CITY OF PORTLAND BUILDING PERMIT

PERMIT ID: 2012-65661

has permission to **1. interior bath renovation 2. enclose porch to create mud room (5.25' x 6.5') 3. Porch additon (6' x 18' 4 3/8") to garage/studio**

City of Portland, Maine - Building or Use Permit

**Proposed
Seasonal Garage/
Studio Plans**

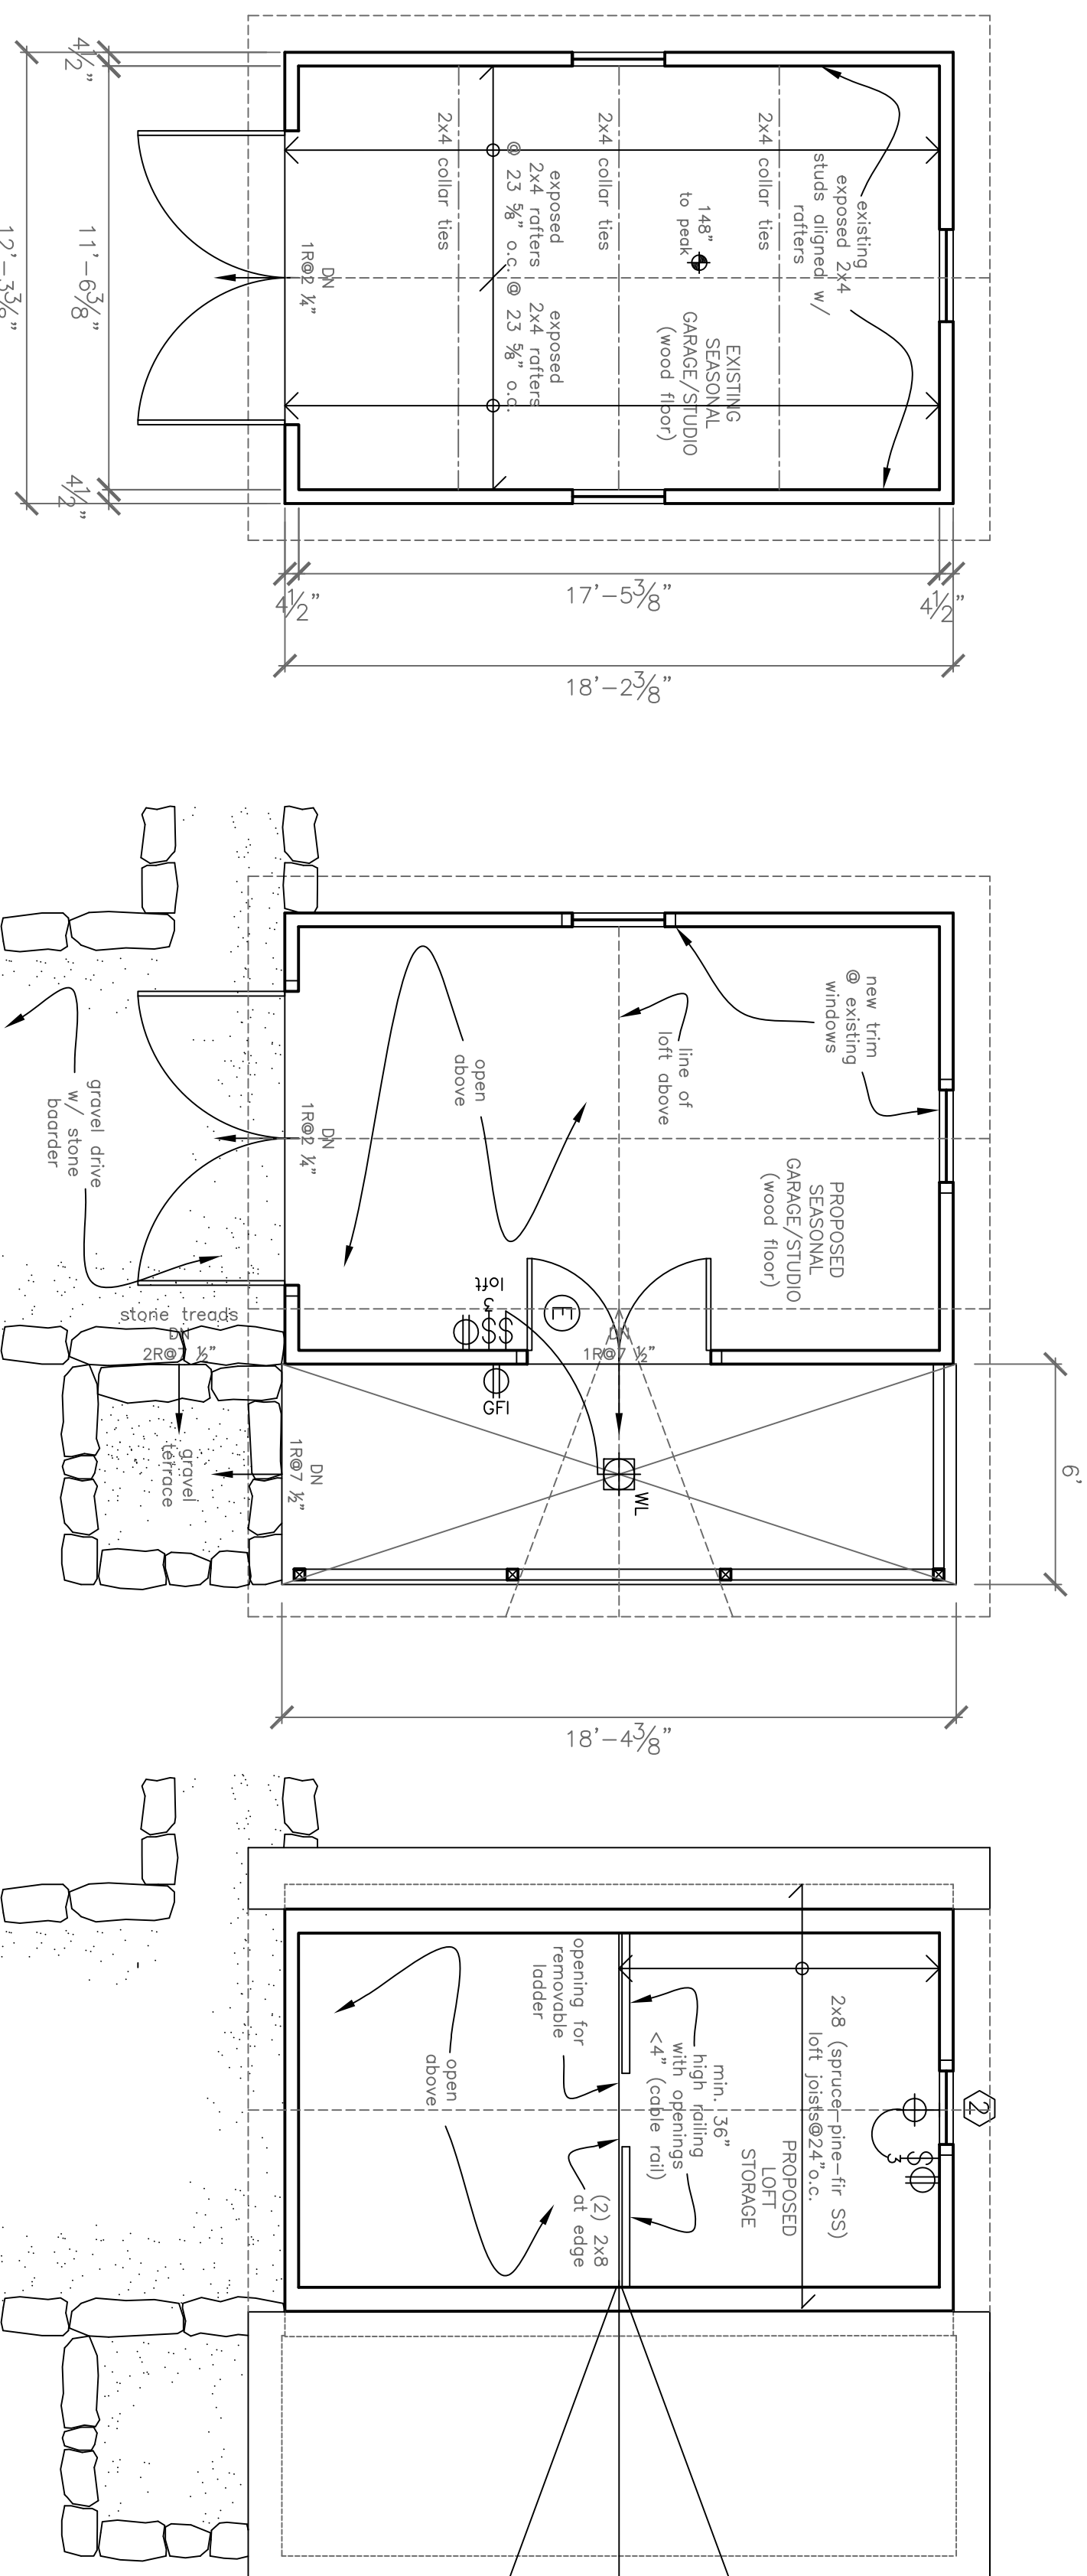
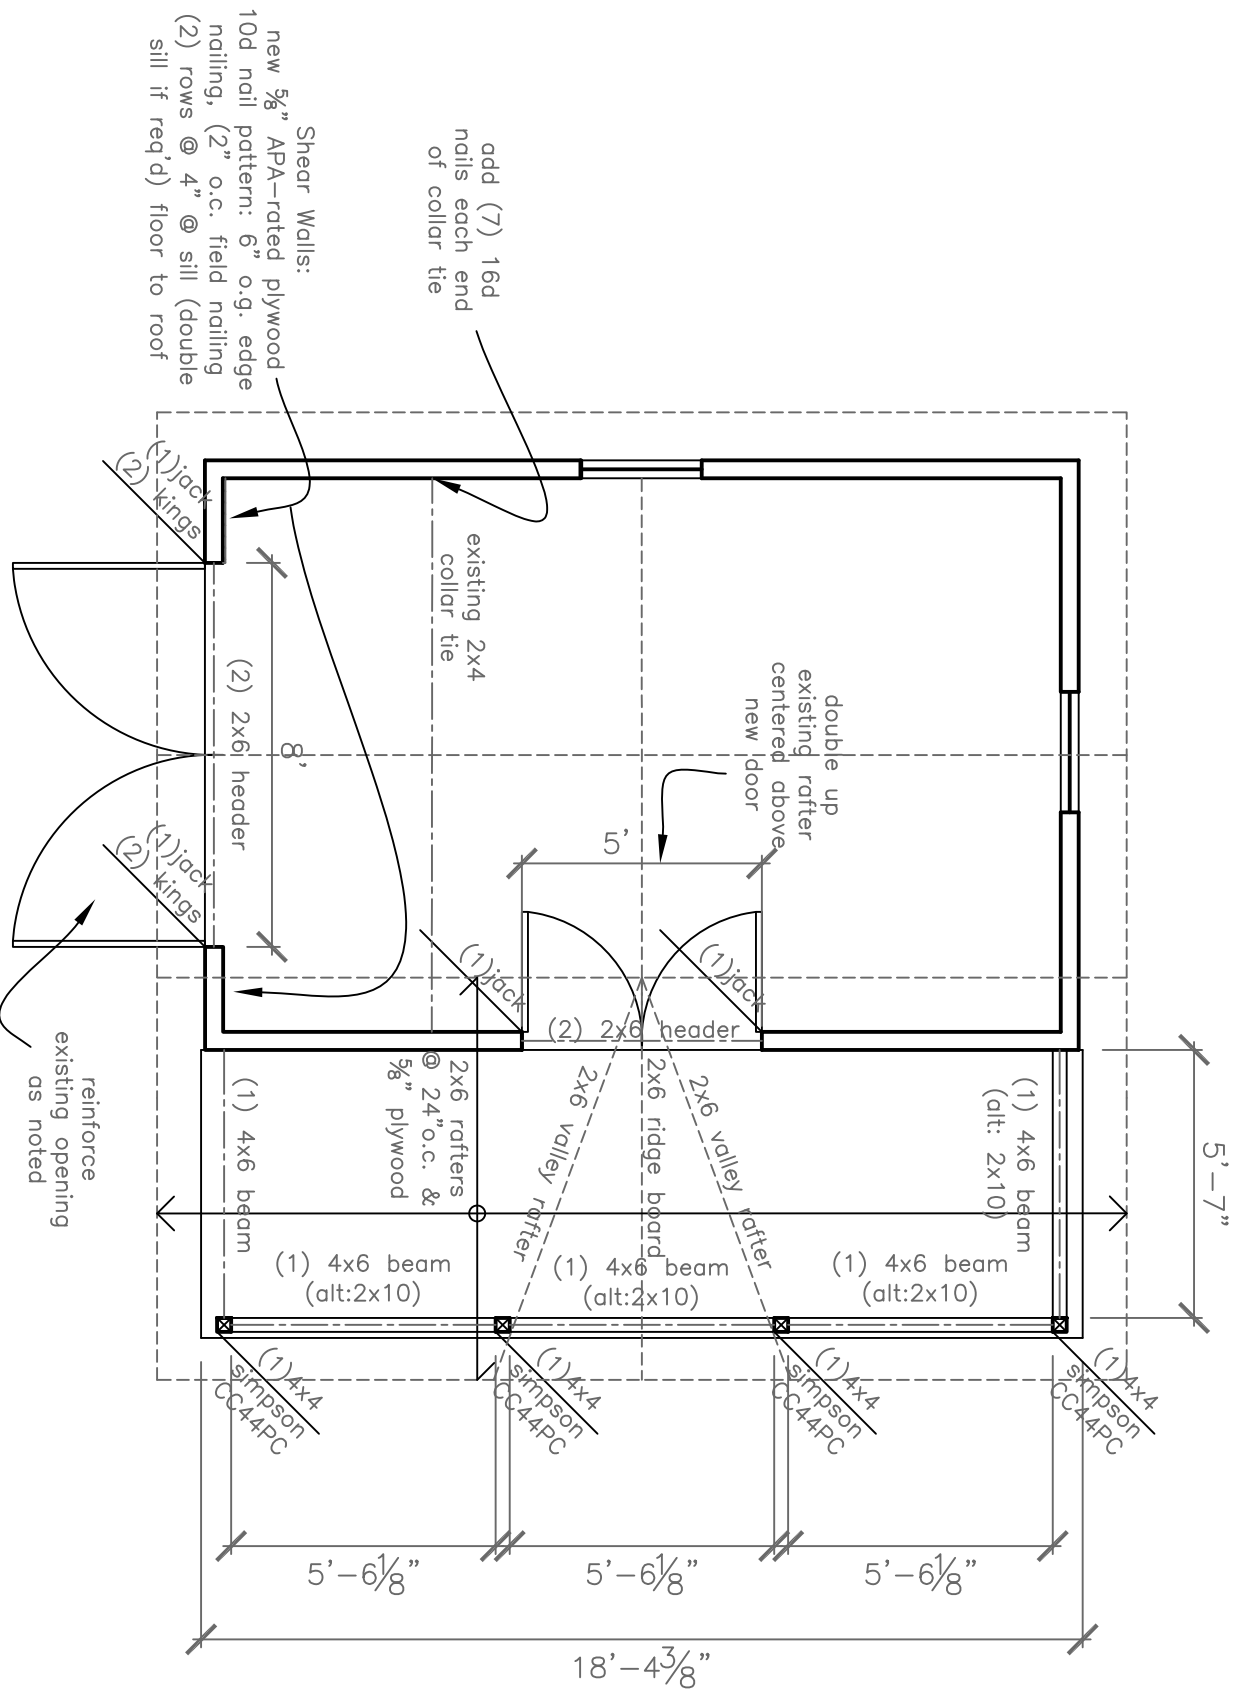
- 5) Note: Plans indicate "4x 6 inch Beam", the Girder must comply with Section R502.5 Allowable girder spans. The allowable spans of girders fabricated of dimension lumber shall not exceed the values set forth in Tables R502.5(1) and R502.5(2), or submit specification from the lumbar yard.

What are the floor joist sizes/ spacing for the proposed entry?

The floor joists for the covered porch are 2x6 at 16"o.c.

**Proposed
Garage/Studio
Elevations and
Cross Section**

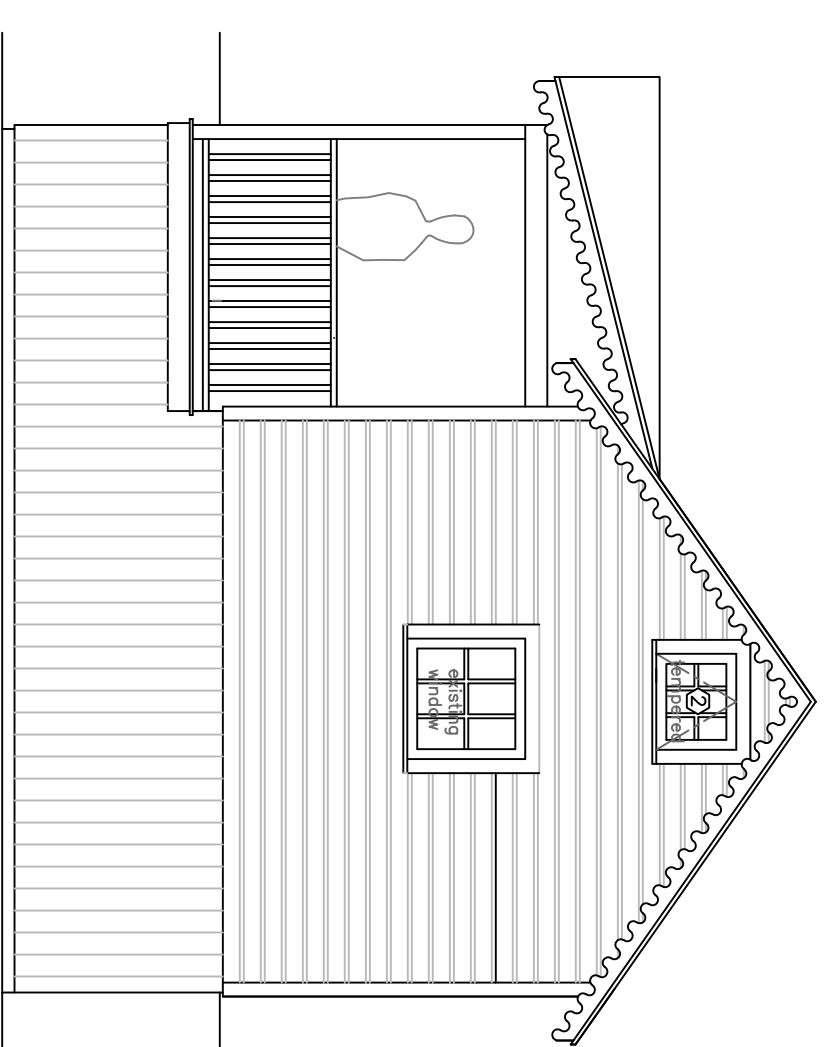
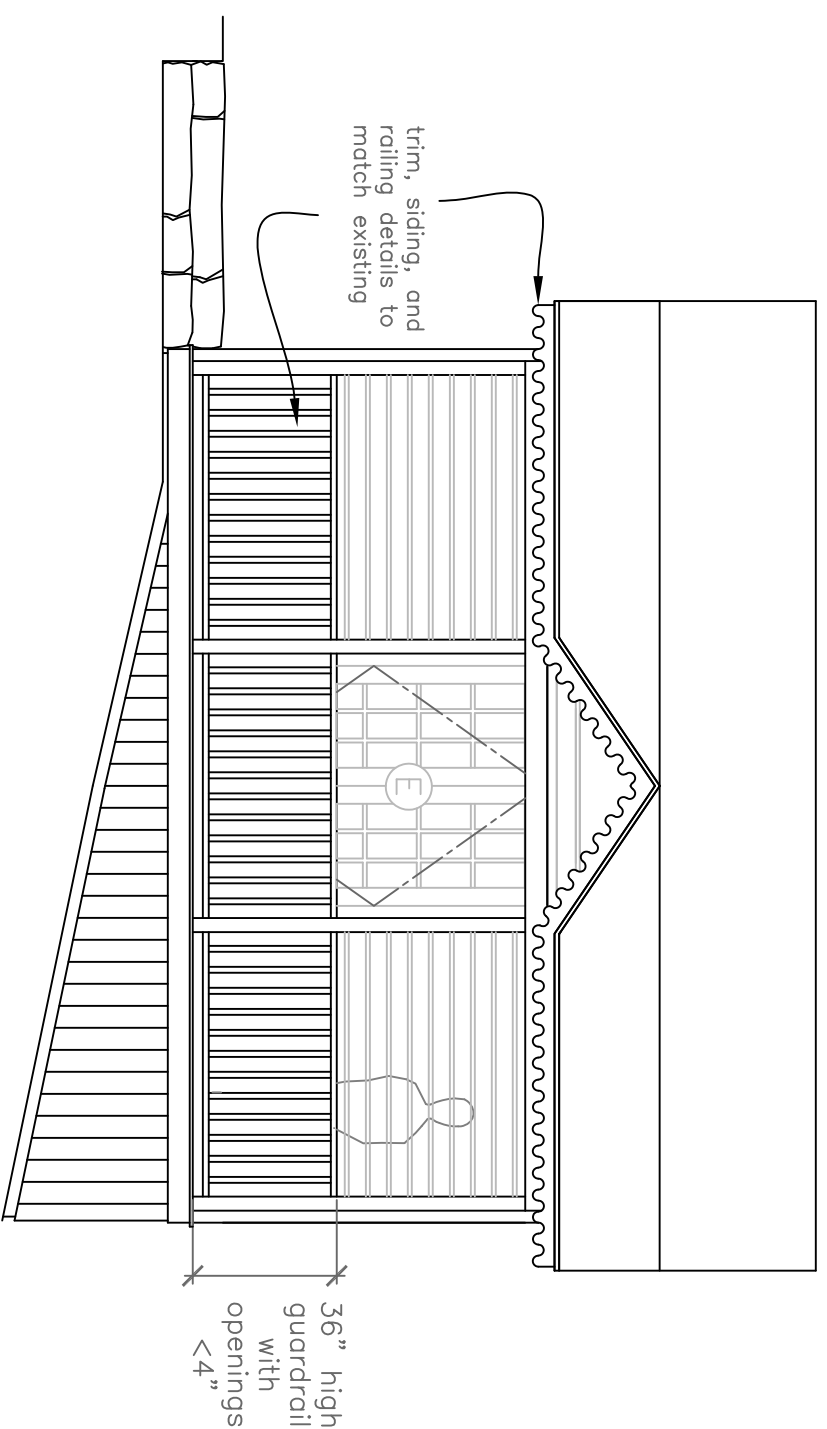
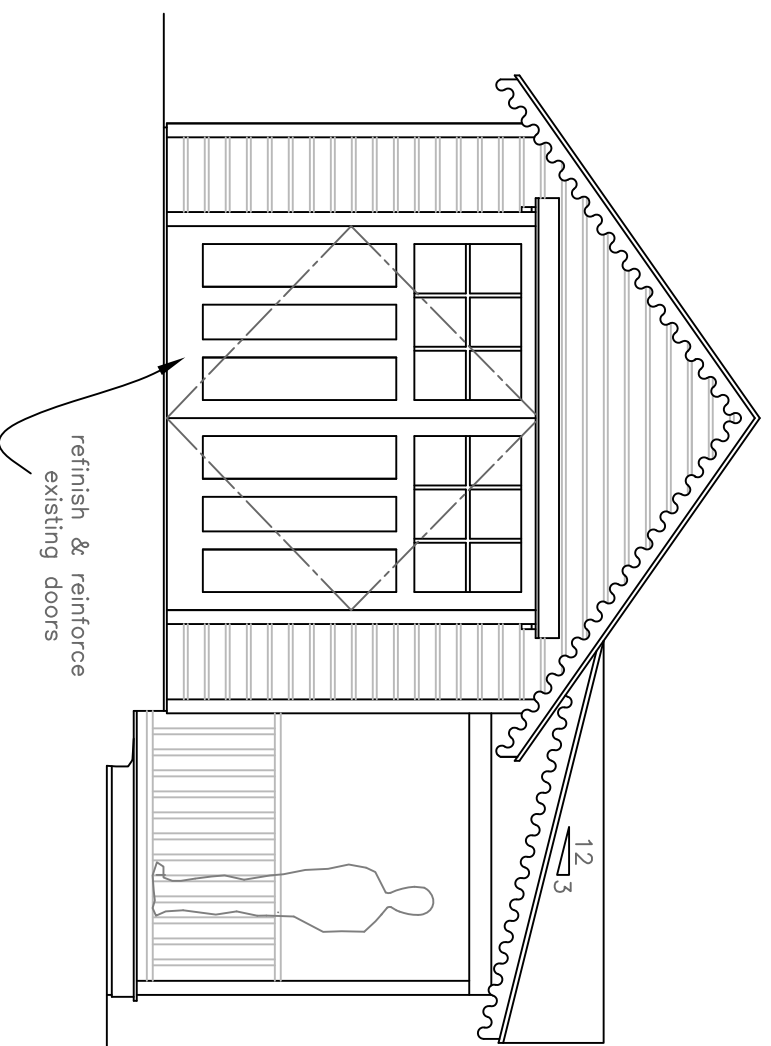
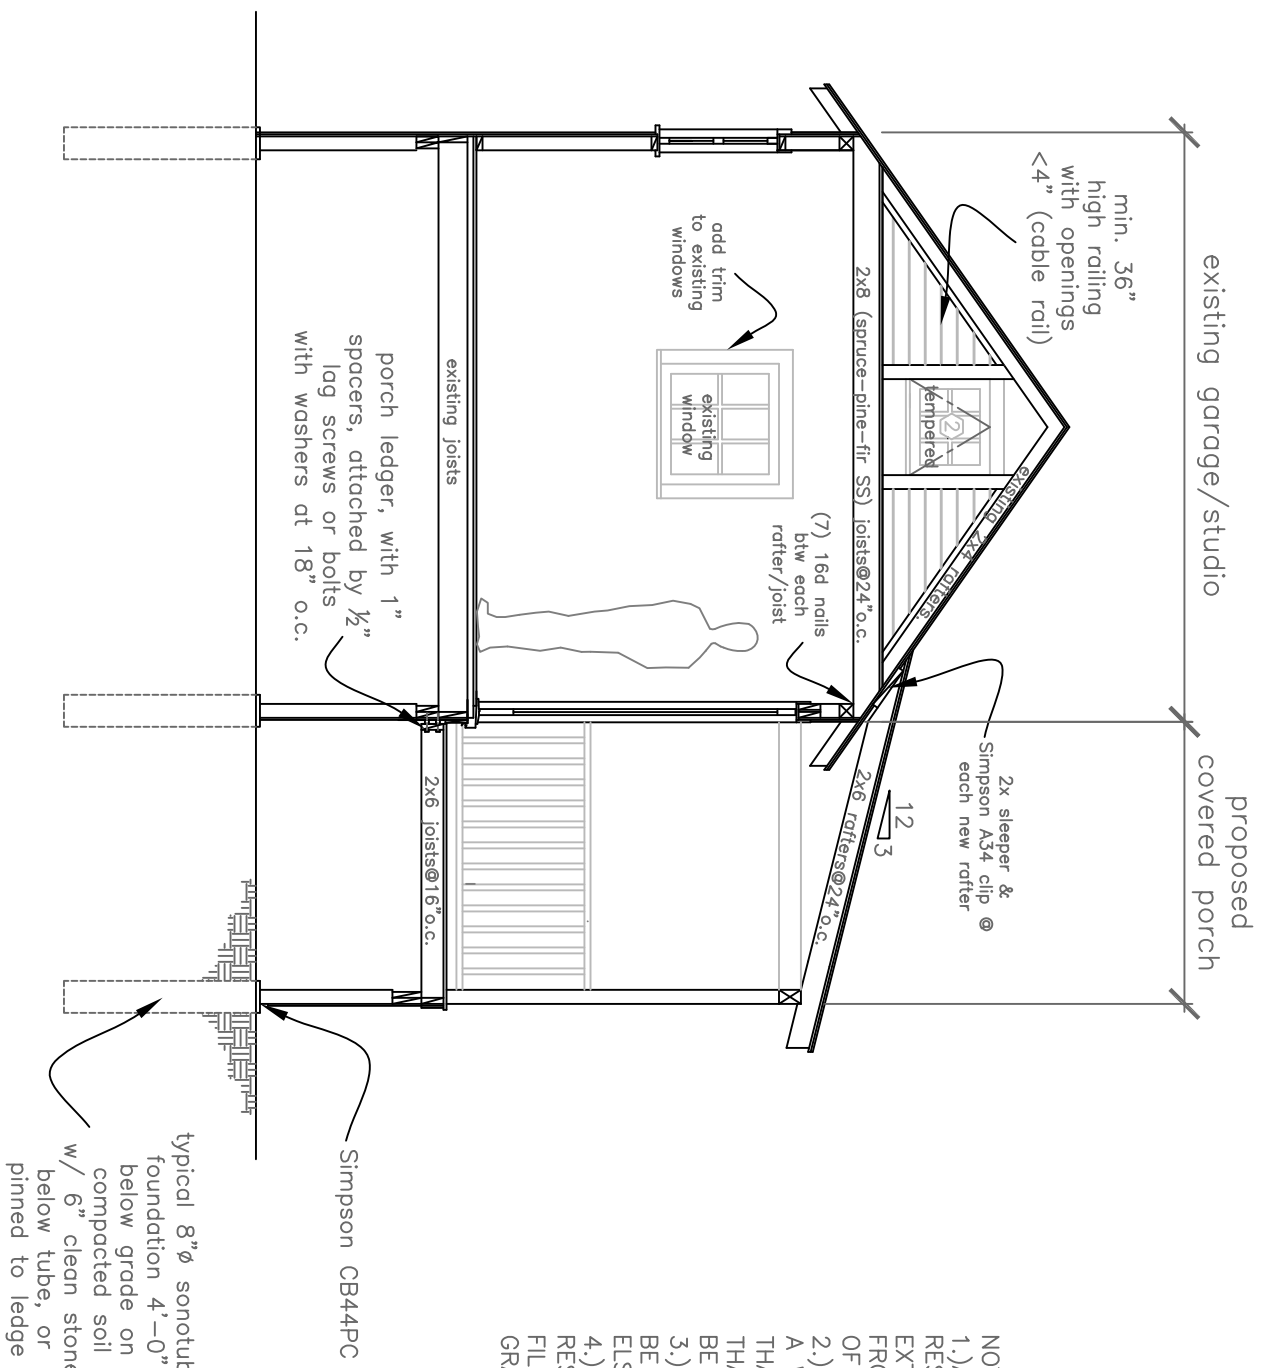
- 8) Section R317 Protection of Wood and Wood Based Products against decay. All wood framing members that rest on concrete or masonry exterior foundation walls and are less than 8 inches from the exposed ground.
